From: Anita Gardner
Sent: 18 April 2017 09:14
To: Karen Parsons
Subject: FW: White Lodge Rectory Lane Angmering - A/207/16/HH and A/208/16/L

From: [REDACTED]
Sent: 04 April 2017 19:30
To: Anita Gardner
Subject: White Lodge Rectory Lane Angmering - A/207/16/HH and A/208/16/L
Importance: High

GROUND FLOOR

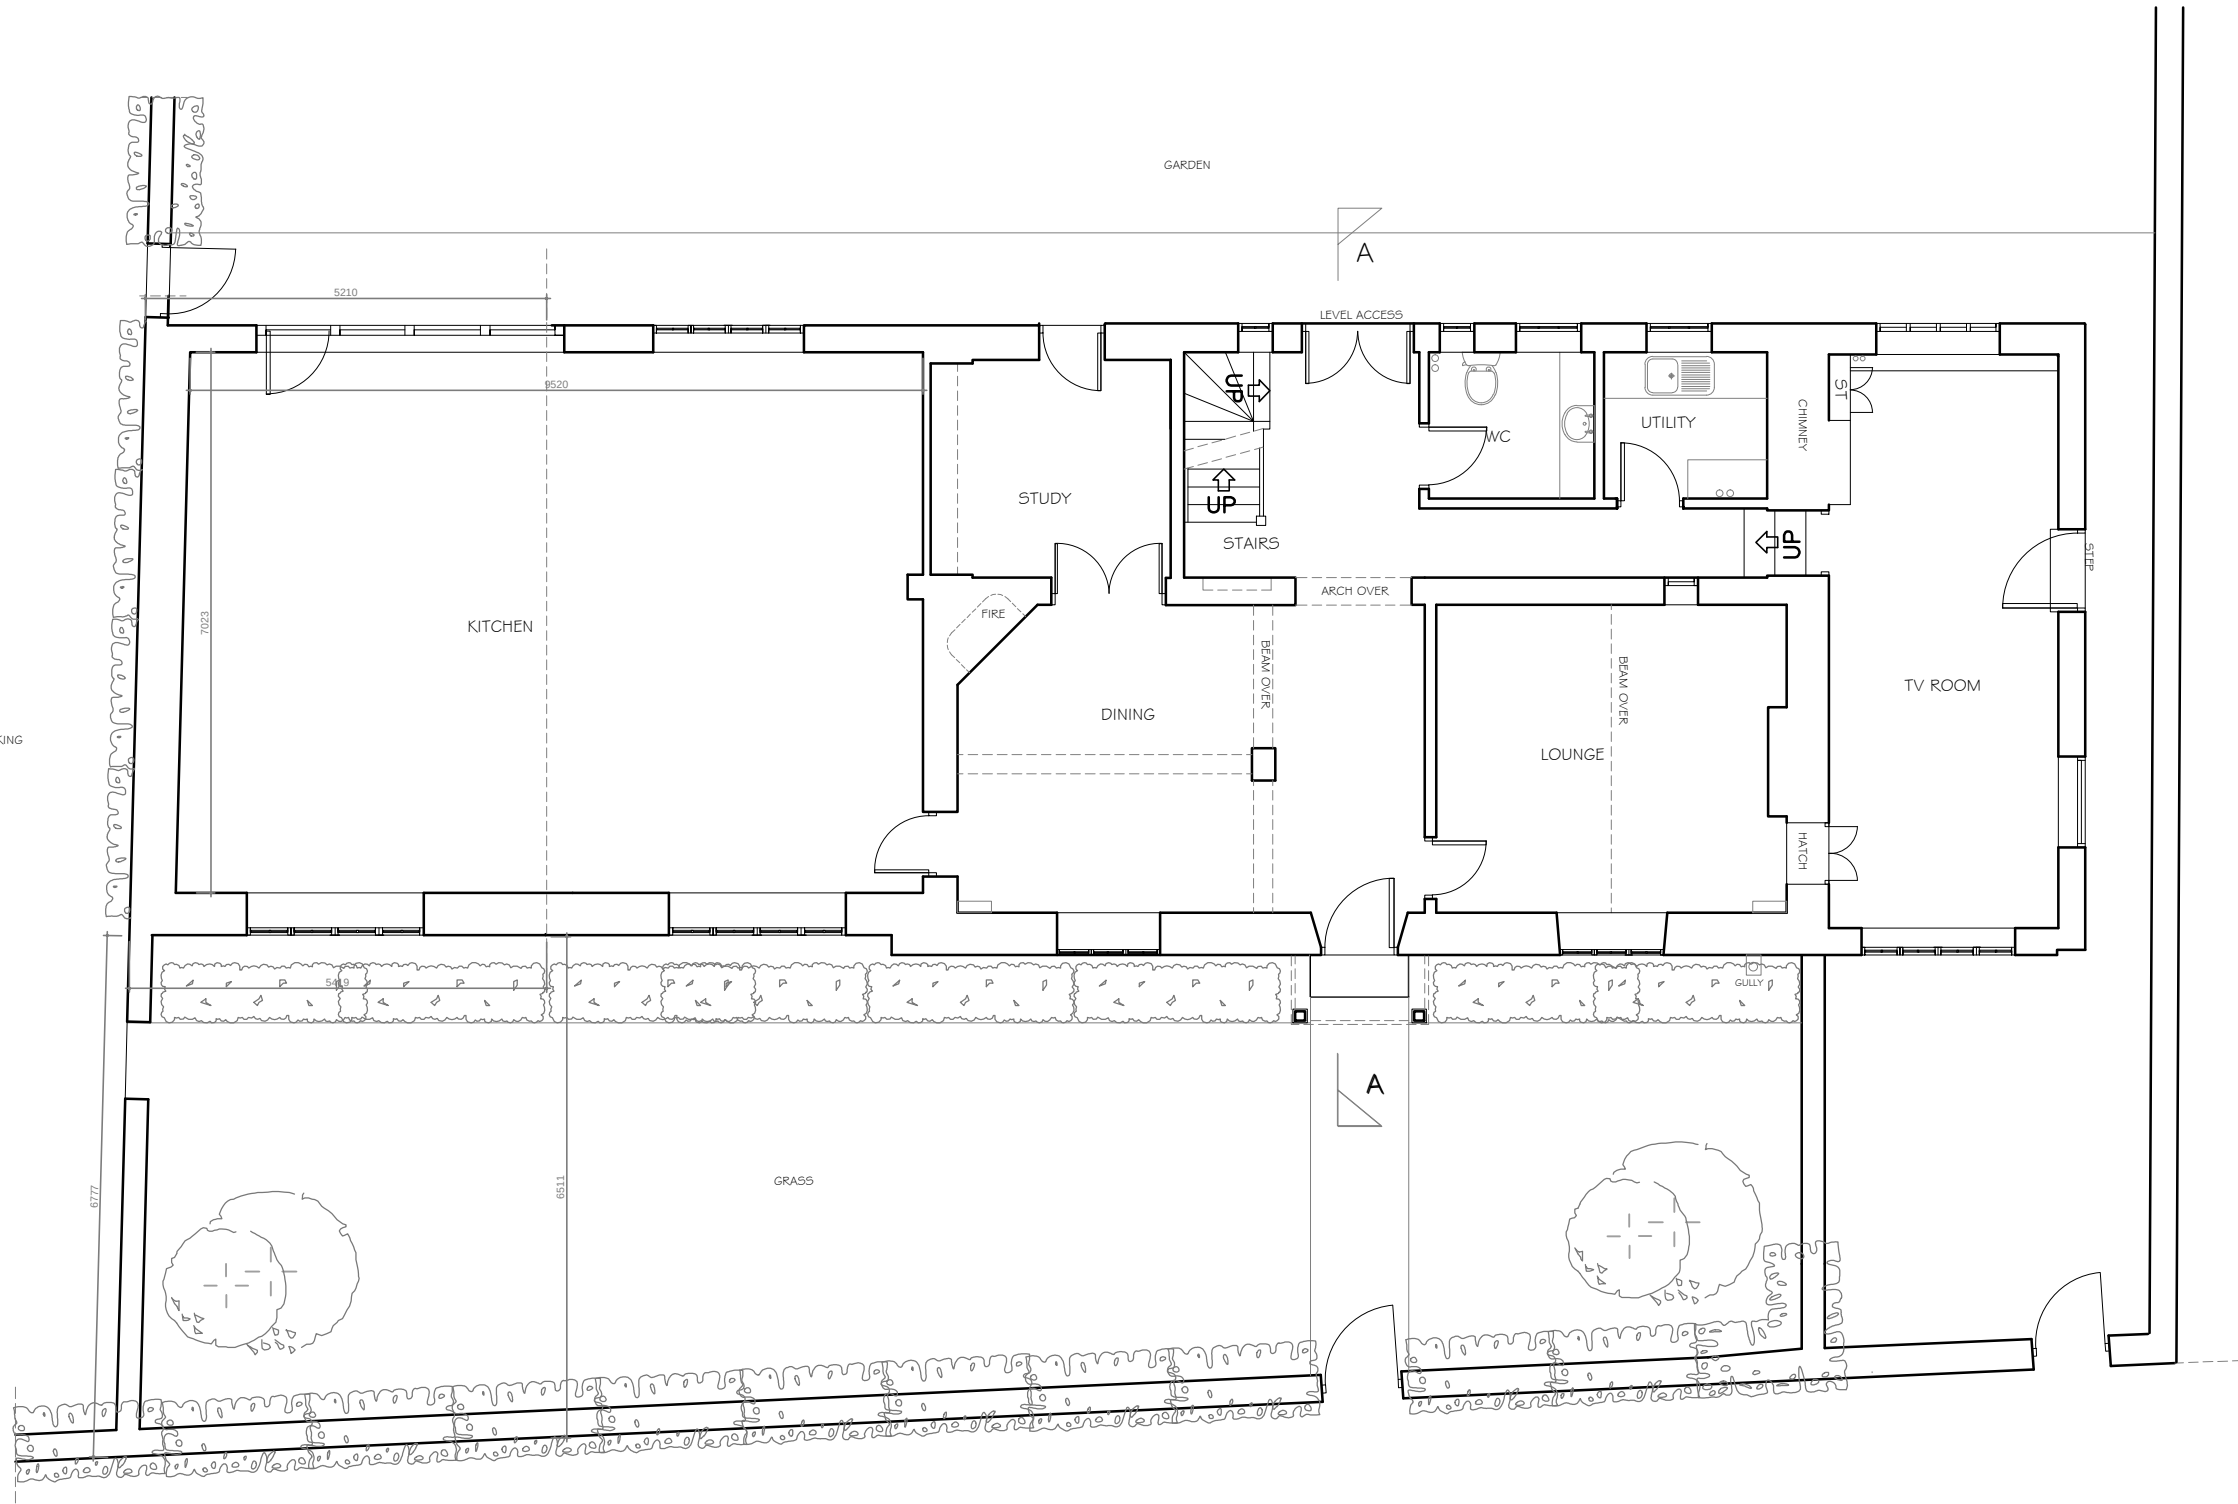
I have substituted the submitted plans for the originals and have discussed the revised plans with Dr Wightman. The design of the actual extension is now acceptable. His only remaining concern is the amount of wall being removed on the ground floor, especially under the beam.

He would rather see the ground floor layout plan amended to retain the side wall of the dwelling up to the limit of the family room with only the dining area open to the kitchen.

Without prejudice I would appreciate receipt of an amended floor plan to detail this area of walling retained .

I am pleased that at last we have an agreed form of external structure however I am very unhappy about the change in his direction on the size of the ground floor internal walls. This was discussed at length with him with my heritage assessor and architect and they agreed that a Nib was required that would show the difference in the two structures and times of construction. This we have clearly done by in two ways 1. By stepping back the line of the extension from the original house both front and back and 2. by keeping enough of the internal walls to show that there was a wall here previously.

The whole principle for the extension is to create a large space for open plan living with a room that is current with the way in which a family house of this size now lives. I am very adamant that this wall is removed to the size as we proposed because to close the room off in the way he suggests would make this room and this sense of space unworkable. We have been extremely accommodating throughout this process and amended everything he has asked for but I feel that I really must at some point take a stance and I feel that his request is not reasonable and does make the extension work.
